From: Peter Cleveland
Sent: 15 September 2011 16:23
To: 'sabine kunze'
Subject: 52 East Front Road

Further to our meeting on Tuesday I have been able to discuss the extensions at the above site with Nik Antoniou (Head of Development Control) and we have discussed the points you raised and looked through the plans which identify the different schemes and of most importance the revised scheme.

SECTION A-A

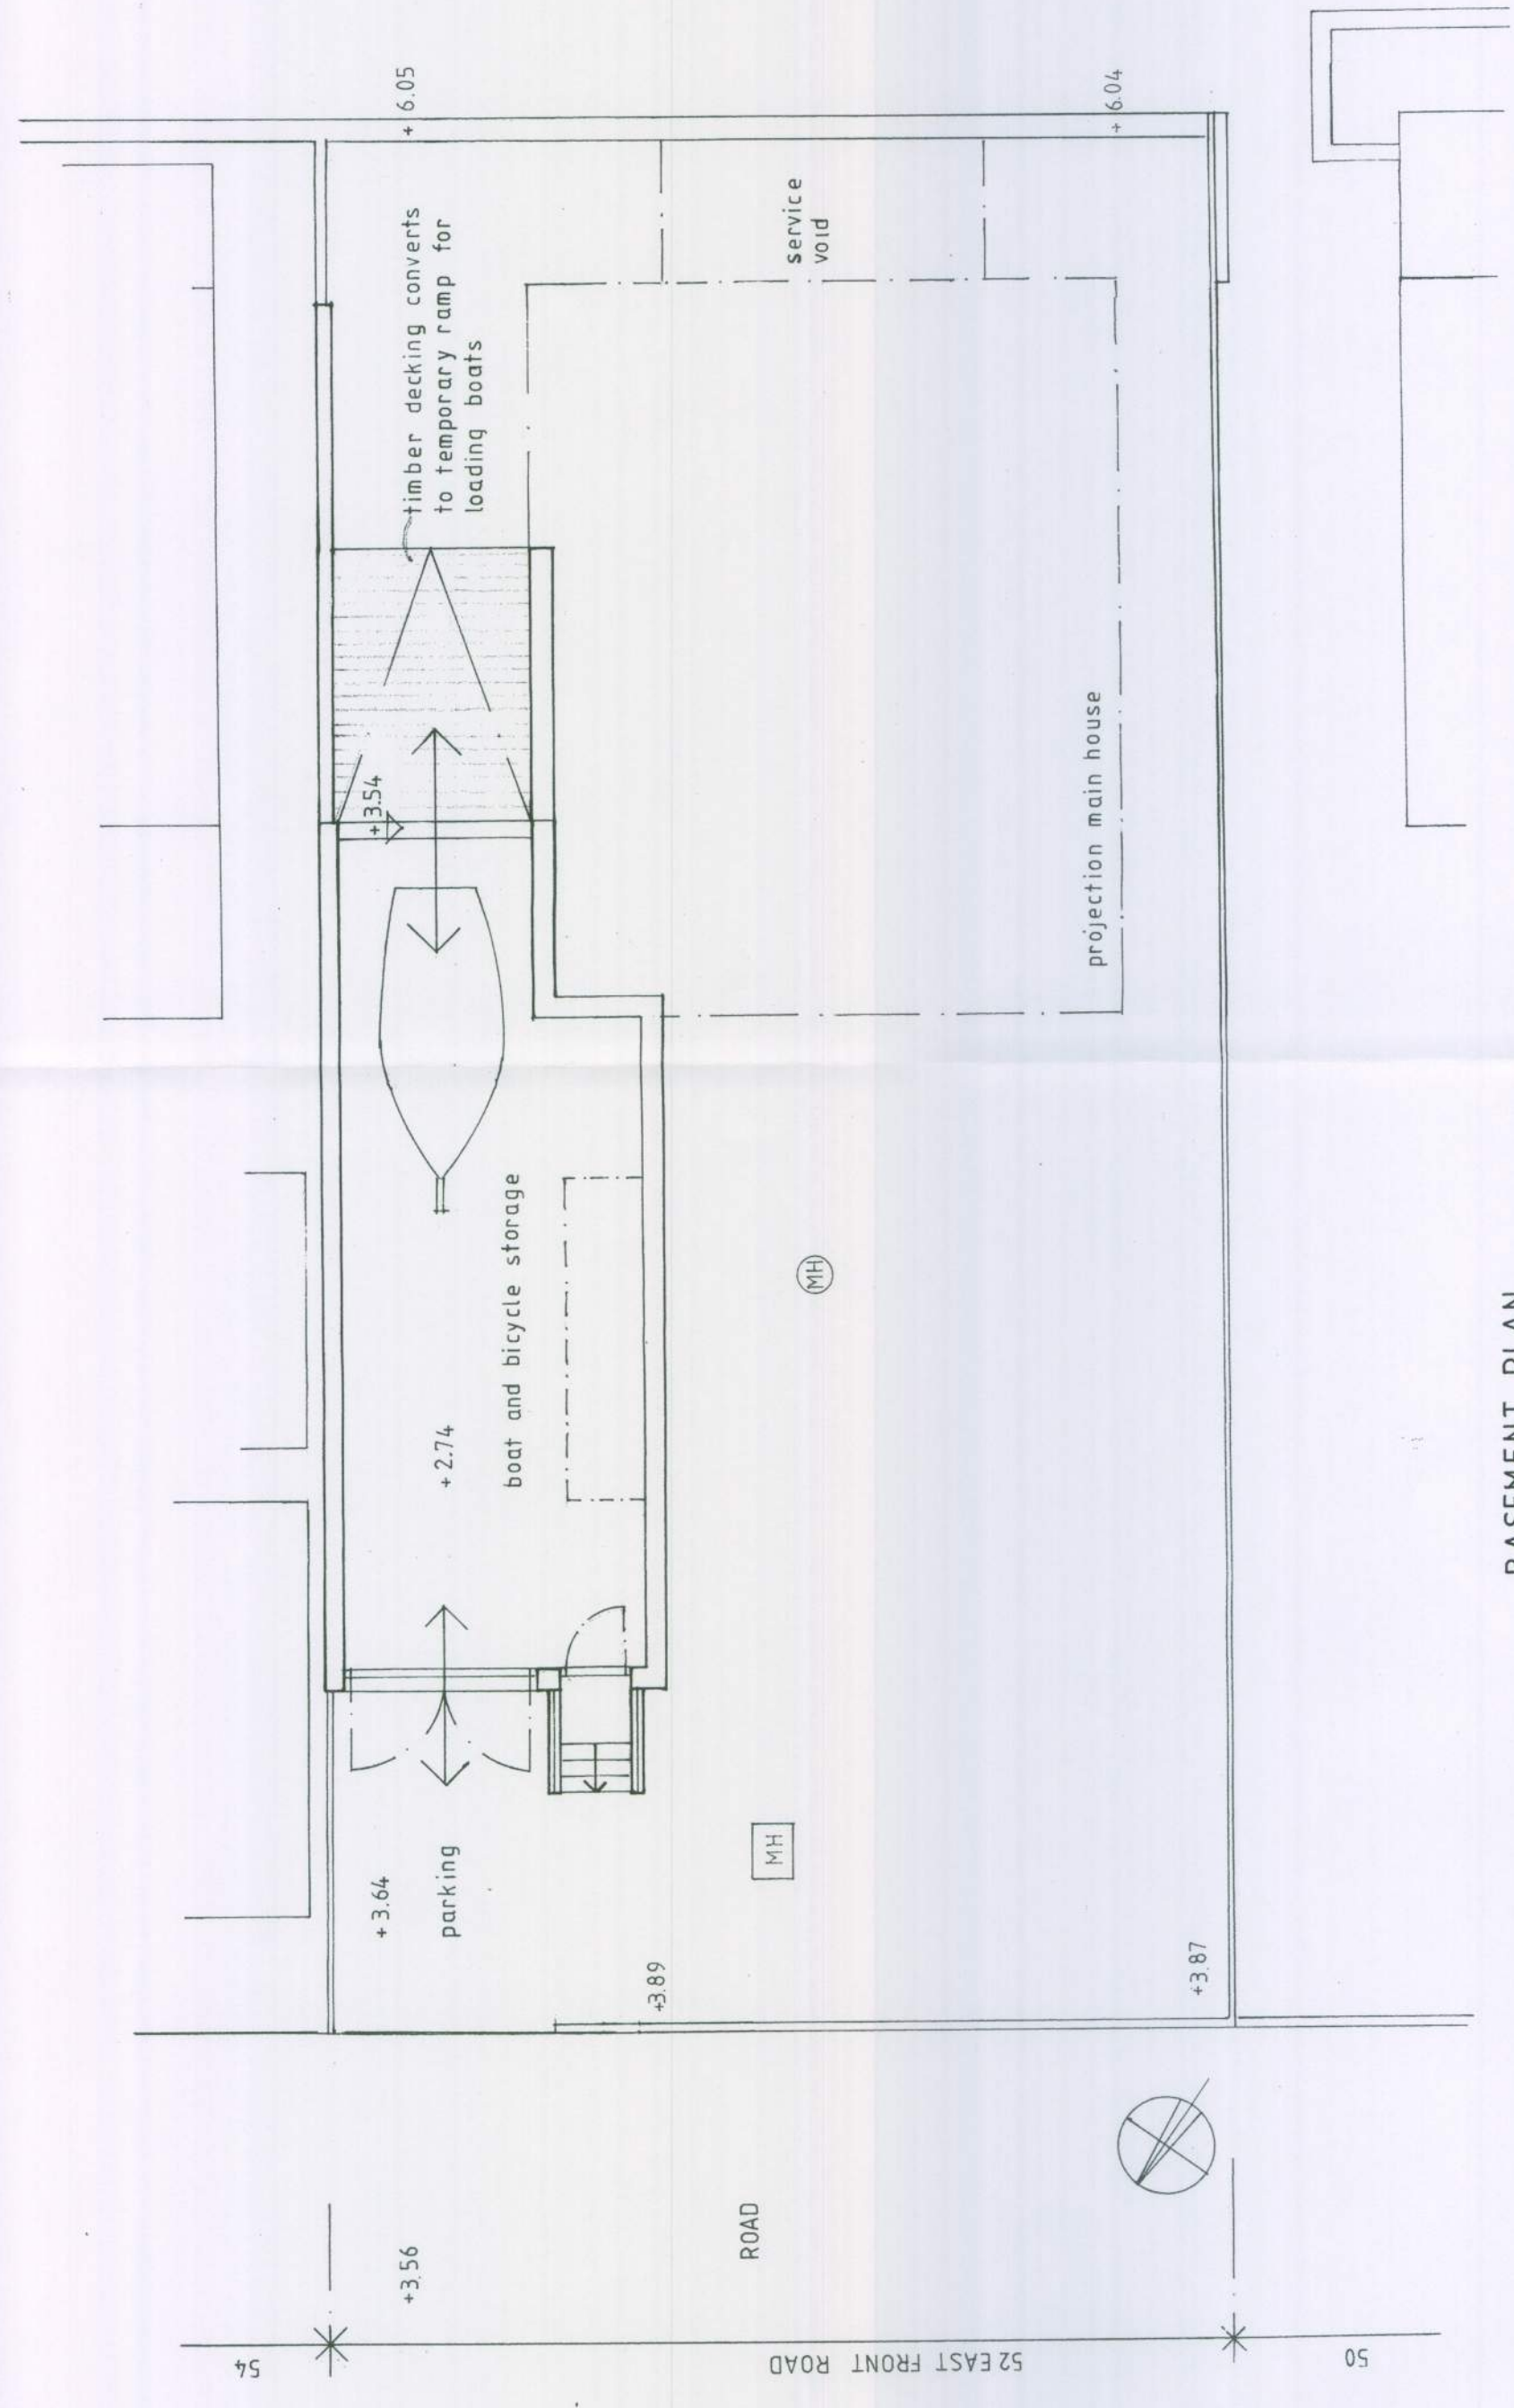
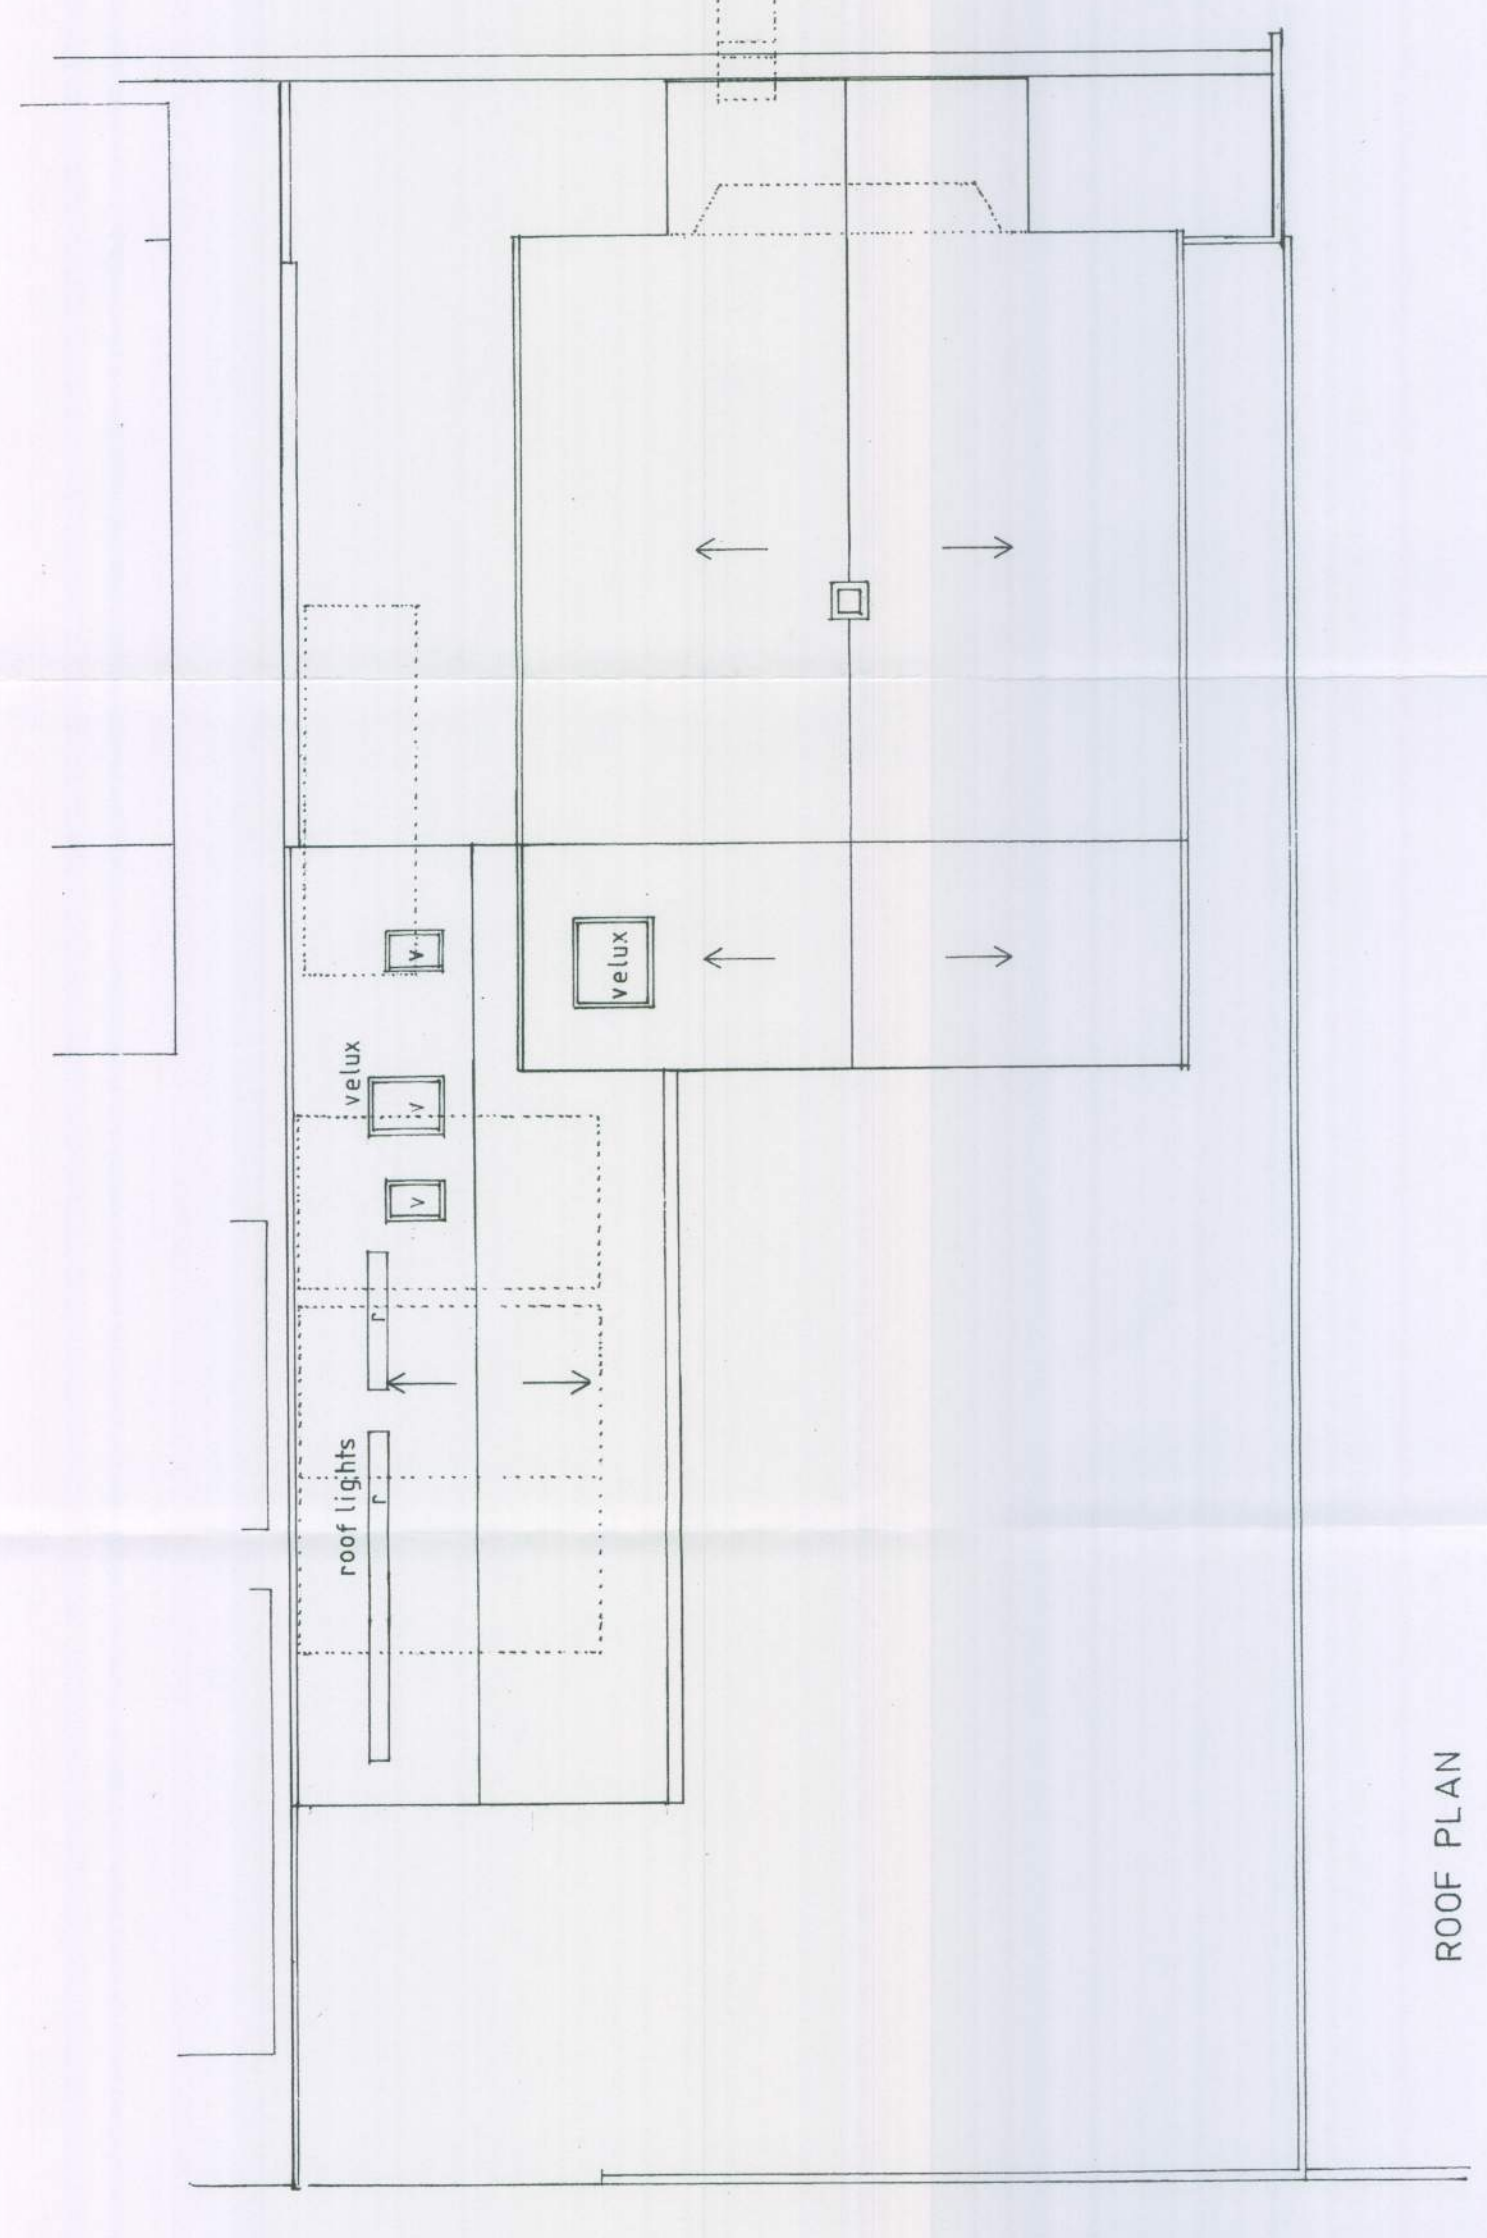
He has agreed with both Jon Parsons and myself that the proposed amendment with the reduction to roof height, width, roof lights etc would be an acceptable scheme to overcome the previous reasons for refusal. As such we suggest that an amended planning application could be submitted to be reconsidered.
